**Your Ref:** OWPC1710  
**Our Ref:** AW/331/13/ 03-12-2013  
**Please ask for:**  
Mrs J Chapman

3rd January 2014

Extensions, structural alterations, balcony & carport  
3 Shorecroft Bognor Regis

Site Plan
Existing and
Proposed

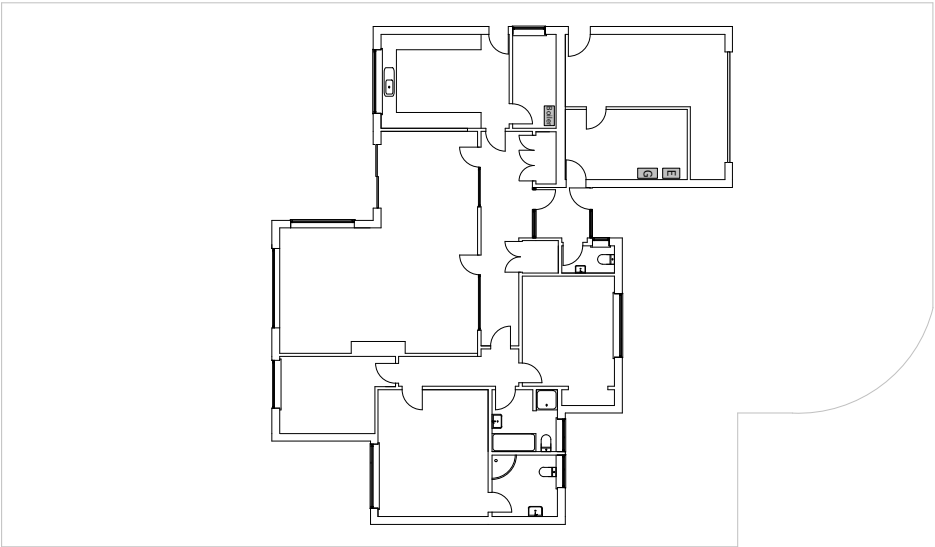
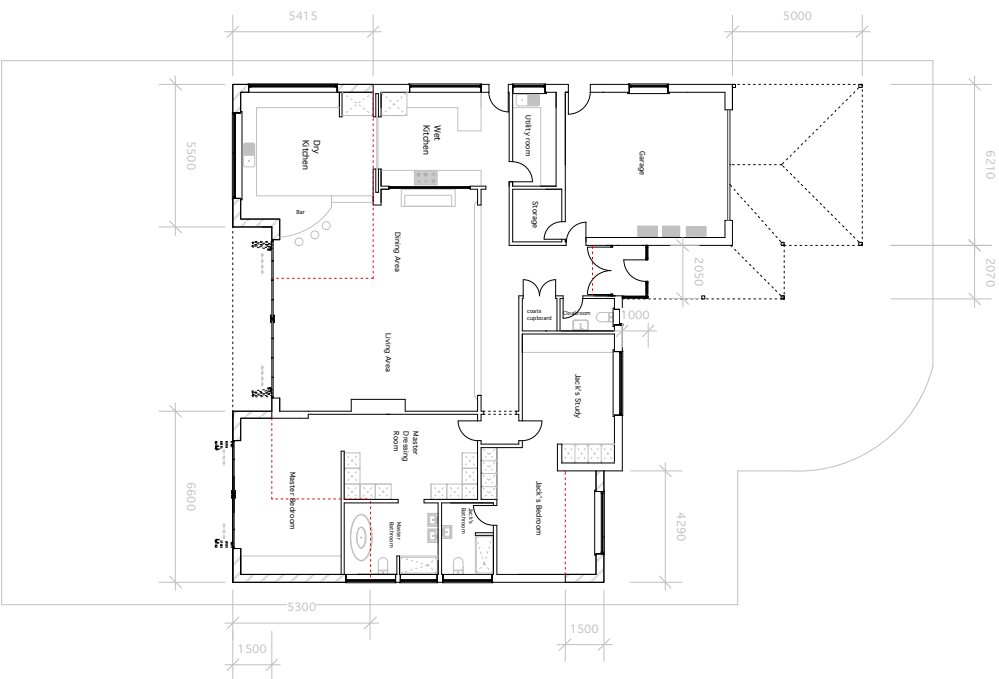
*The measurements on the plans are very faint but, if I have read them correctly, the car port and covered walkway will dominate the front of the bungalow - the car port appears to extend 5000 mm from the front of the existing garage doors.*

*The existing garage extends 4000mm so new flat roof will extend 9000mm (29ft)*

*At the widest part, the flat roof will be 6210mm width of garage + 2070mm walkway = 8280mm (27ft)*

*Please advise if I am looking at correct plans and measurements.*

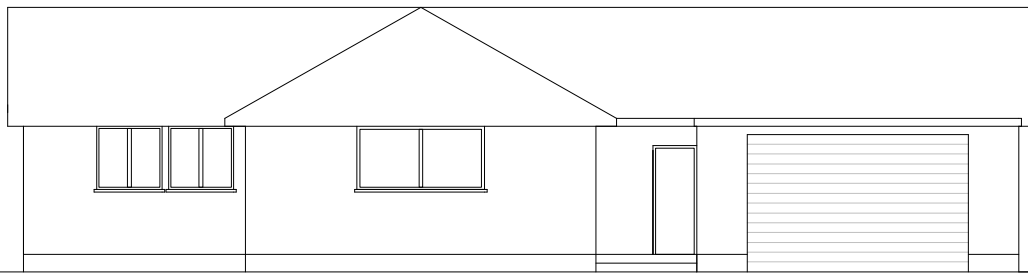
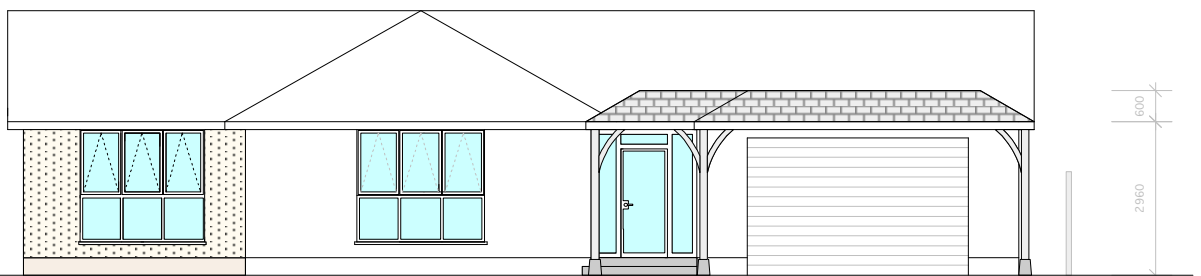
*Are the plans actually correct as a letter dated 12 Dec 'signed' by Karl Roberts states things like ..... 'being validated by Mrs J Grieves'..... 'unable to accept..... plans do not scale correctly'..... 'proposed north elevation missing cloakroom window'.....'provide above before 26th Dec'*
